WEST SUSSEX COUNTY COUNCIL CONSULTATION

TO:	Arun District Council FAO: Maria Tomalova
FROM:	WSCC - Highways Authority
DATE:	10 June 2019
LOCATION:	8 Mead Court Mead Lane Bognor Regis PO22 8BL
SUBJECT:	BR/154/19/PL Change of use from single dwelling (currently used as a house in multiple occupation with 6 bedrooms) into a house in multiple occupation with 8 bedrooms including the conversion of existing integral garage into living area. This application affects the character & appearance of the Upper Bognor Road & Mead Lane Conservation Area & may affect the setting of a listed building.
DATE OF SITE VISIT:	
RECOMMENDATION:	Advice
S106 CONTRIBUTION TOTAL:

SITE PLAN - 1/500

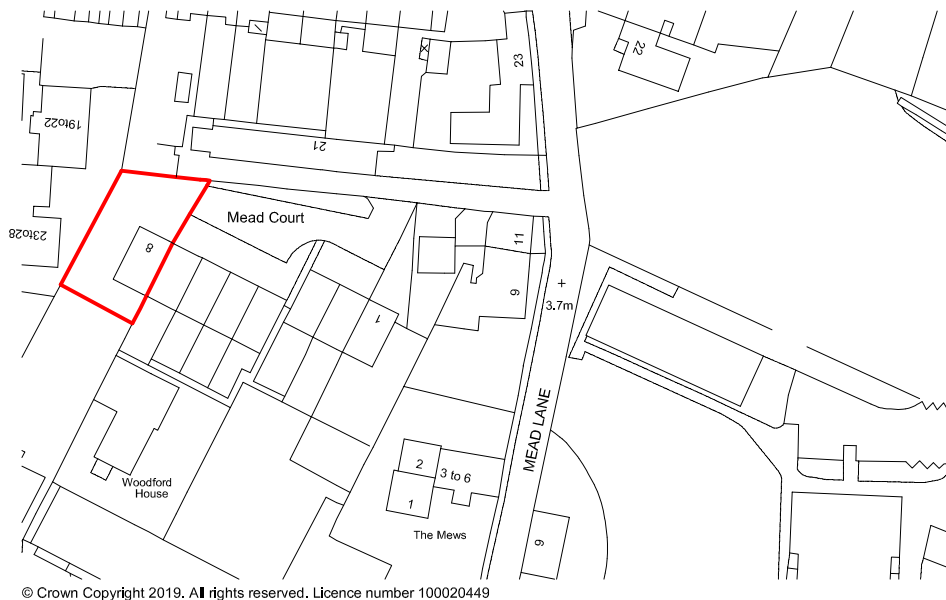
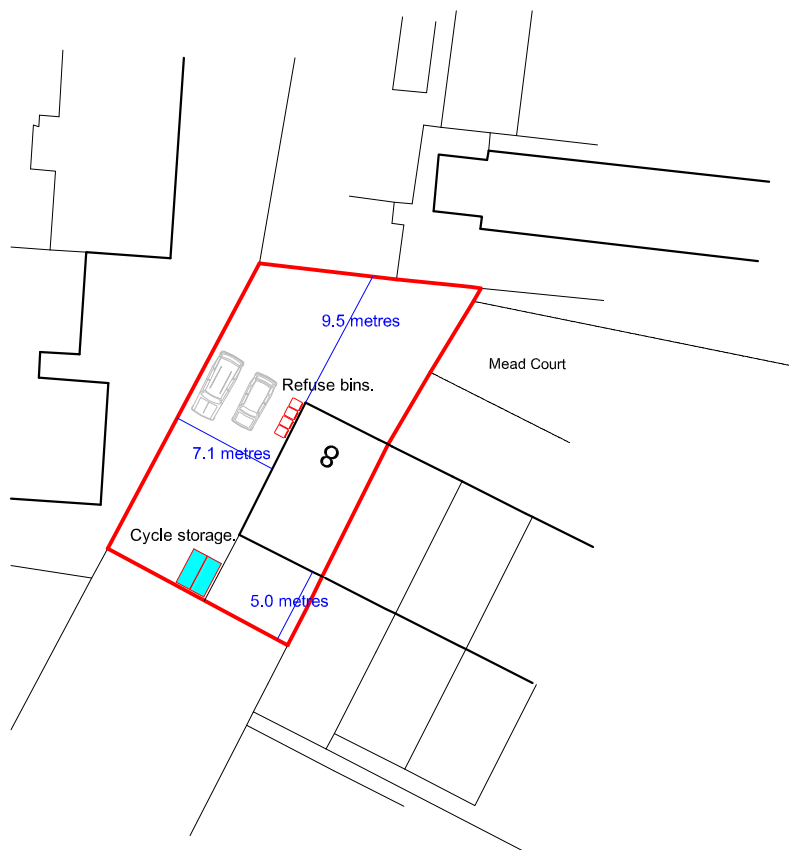
The current proposed plans meet the Vehicle Parking standards and Cycle Parking Standards set out by WSCC.

Although Manual for Streets does state that residents should not have to travel over 30m to put bins out and collection vehicles should not have to travel in excess of 25m to collect/deposit bins. This is however a matter of amenity for the Local Planning Authority (LPA) to consider. The applicant is advised to contact the waste disposal authorities to ascertain whether the practise would be acceptable.
